BR/99/20/PL

23 Mead Lane Bognor Regis PO22 8AP

Change of use from Student Accommodation to 3 No. dwellings, comprising 1 No. 1 bed apartment, 1 No. 2 bedroom house & 1 No. 3 bedroom house. This application affects the character & appearance of the Upper Bognor Road & Mead Lane Conservation Area & may affect the setting of a Listed Building

SOUTHERN ELEVATION

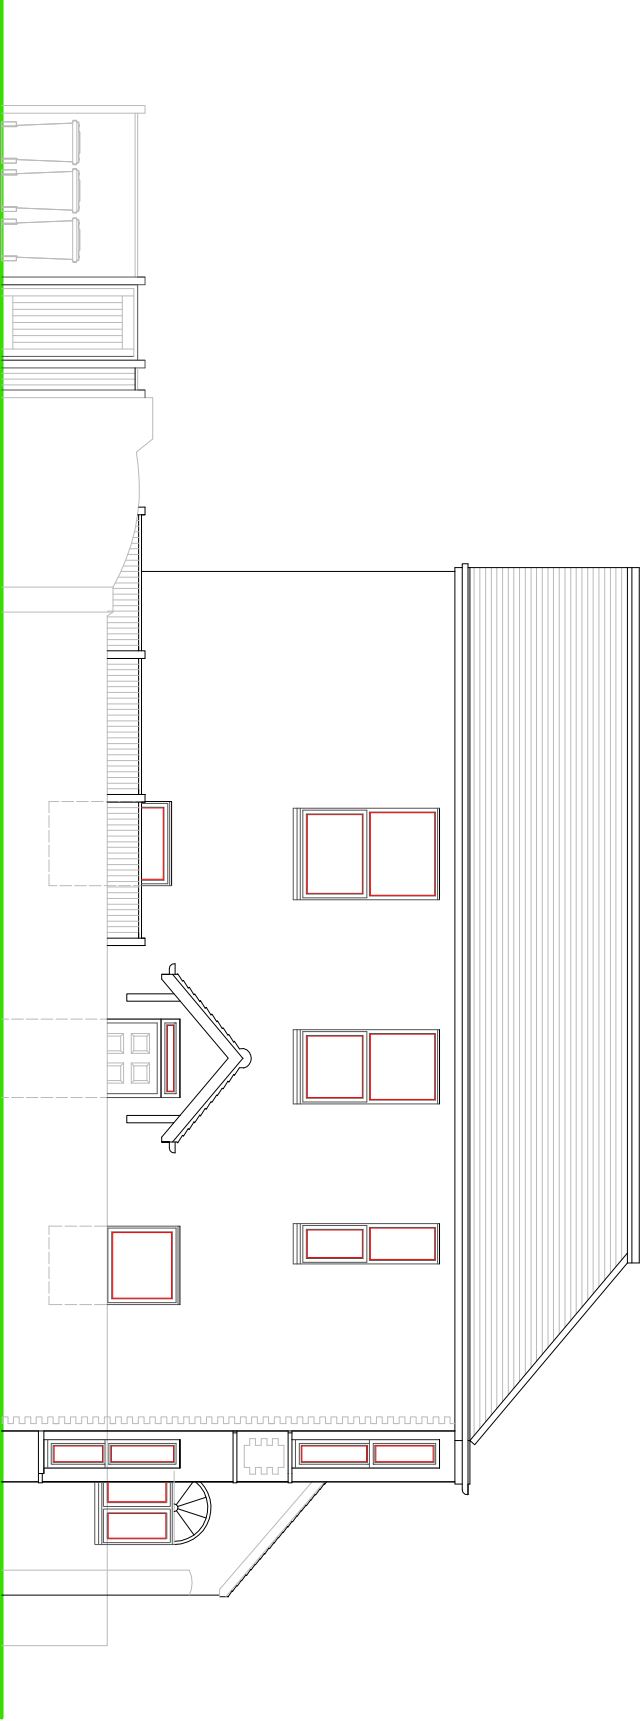
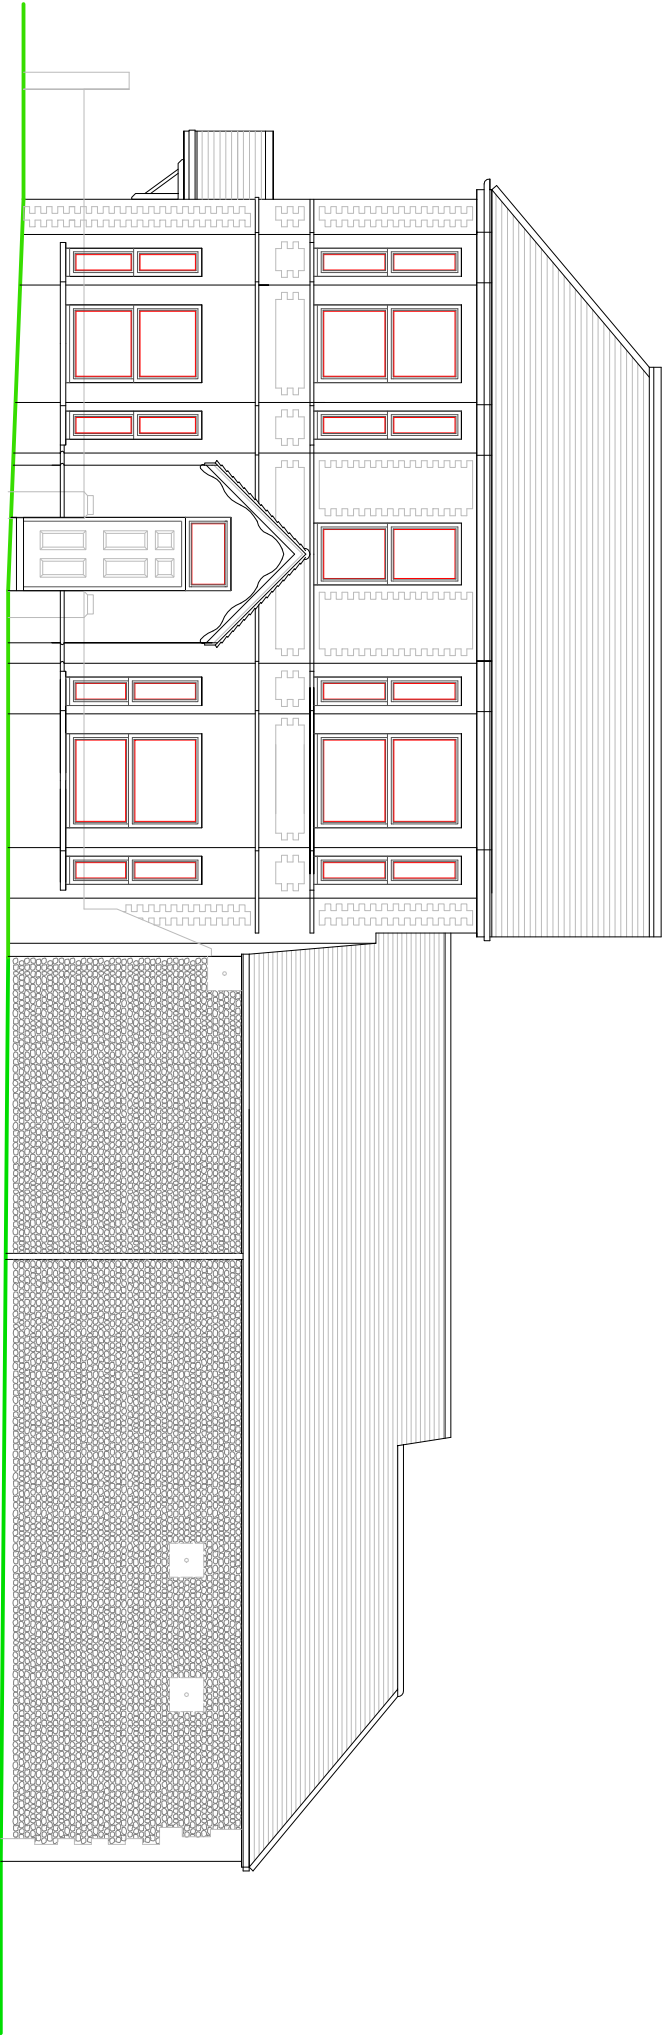
On reviewing the plans, I have noted that the proposed front doorway to Unit 3 seems to be shown as a window instead of a door on the proposed south elevation. This issue should be amended on the relevant drawings.

WESTERN ELEVATION

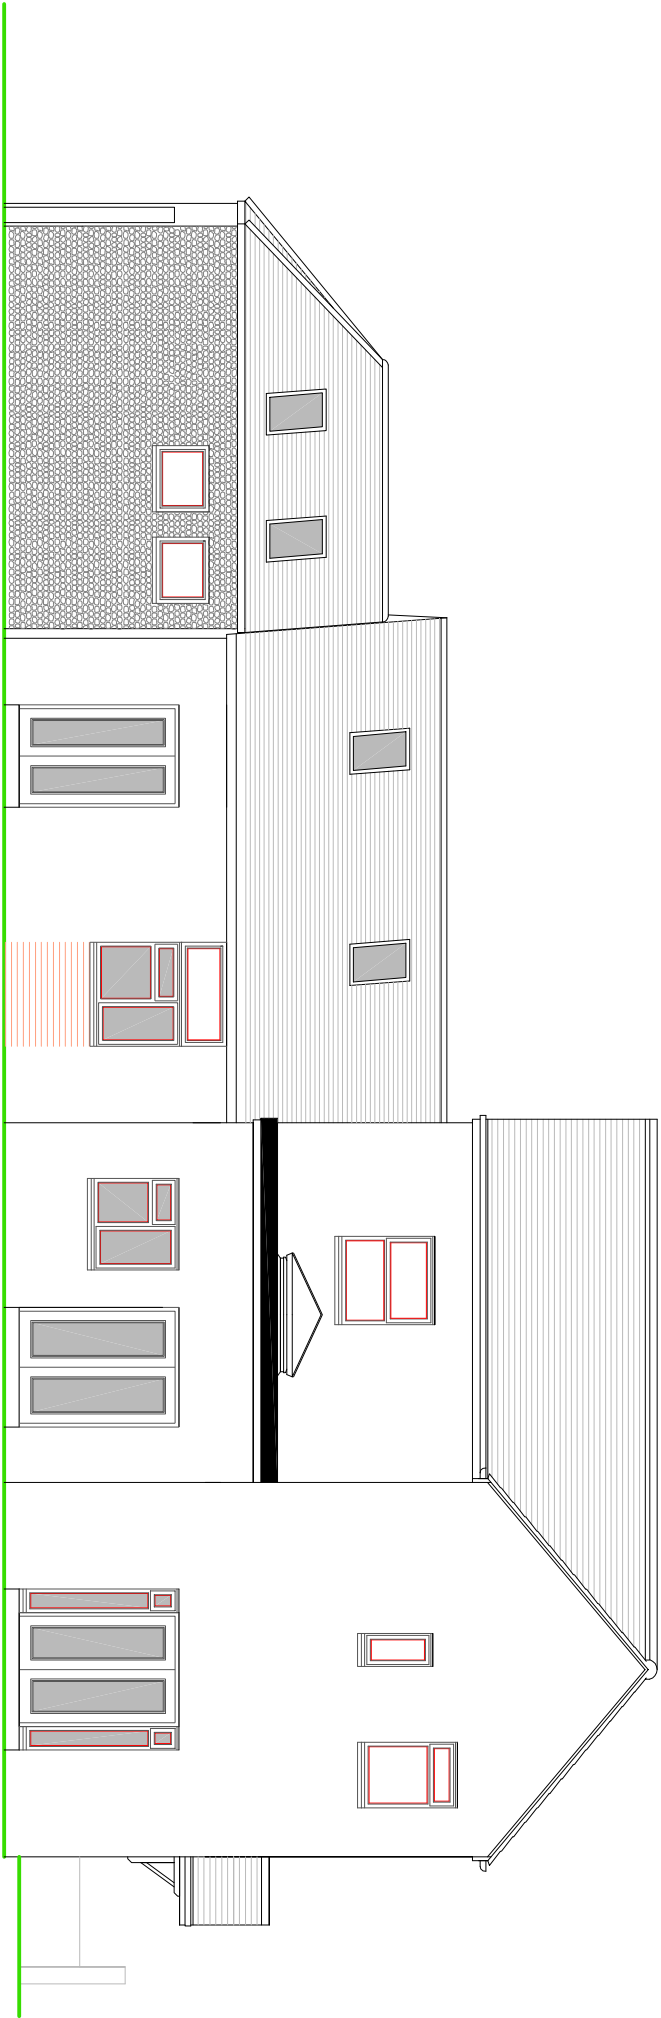
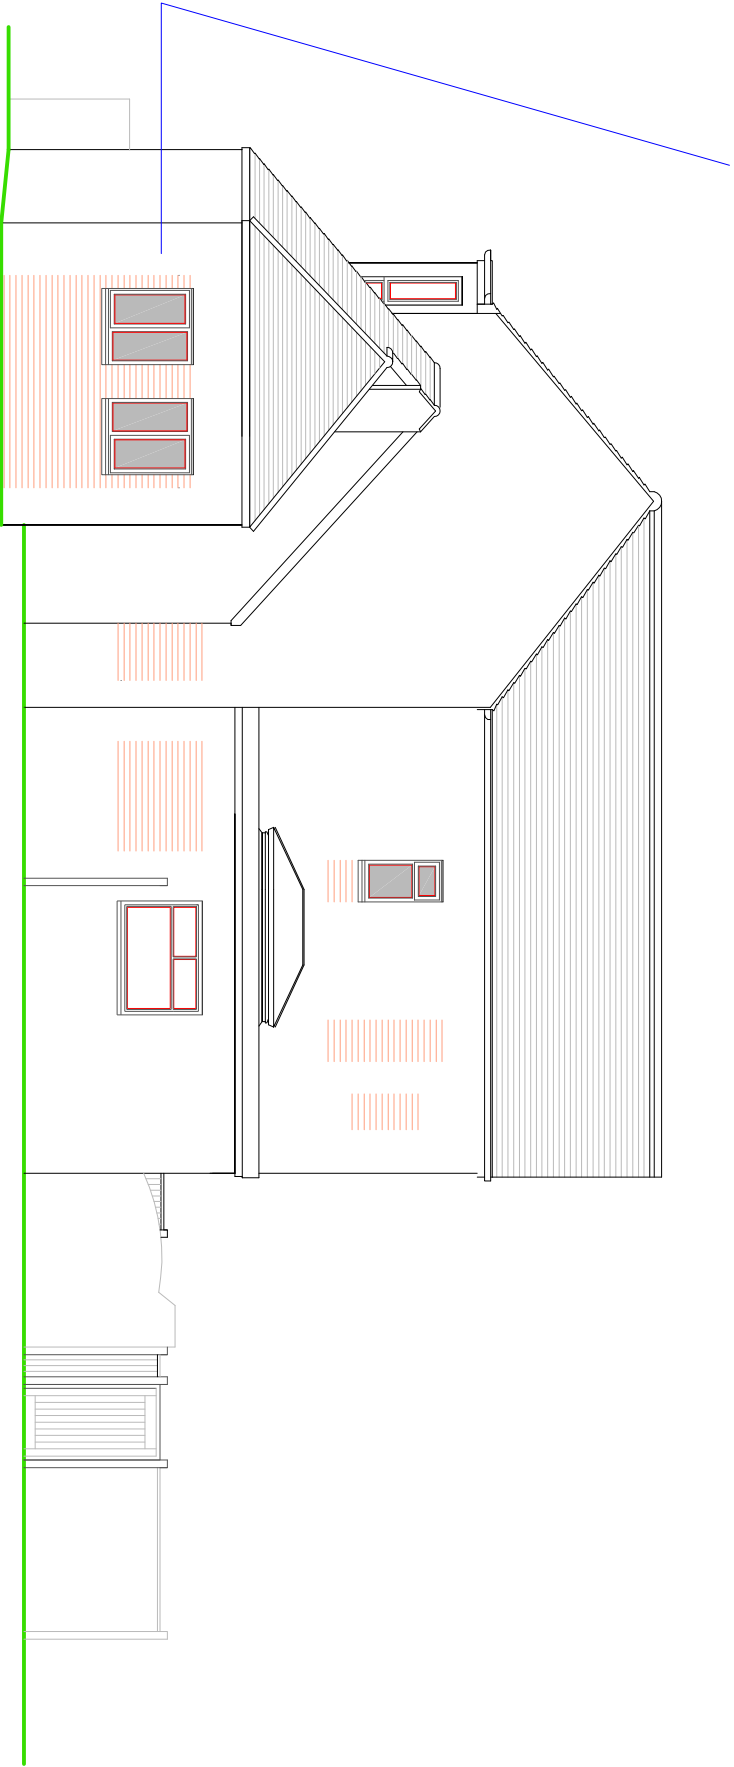
Whilst I am happy for the northern brick wall of the northern element of the building to be infilled, this will require some careful consideration, partly as a result of it being visible from the lane. This will require the materials to match in terms of colour and appearance to the existing and that the existing bond is followed. Details of the bond could be supplied to the council by way of condition, if minded to approved the application. I believe that it is positive to note that the attractive flint walling on the eastern elevation will not be altered in any way.

It is also considered important that the any new joinery which is visible form the public realm should be appropriate for the conservation area. For instance, the two new windows in the northern element of the building where it is suggested that they be timber side hung casements.
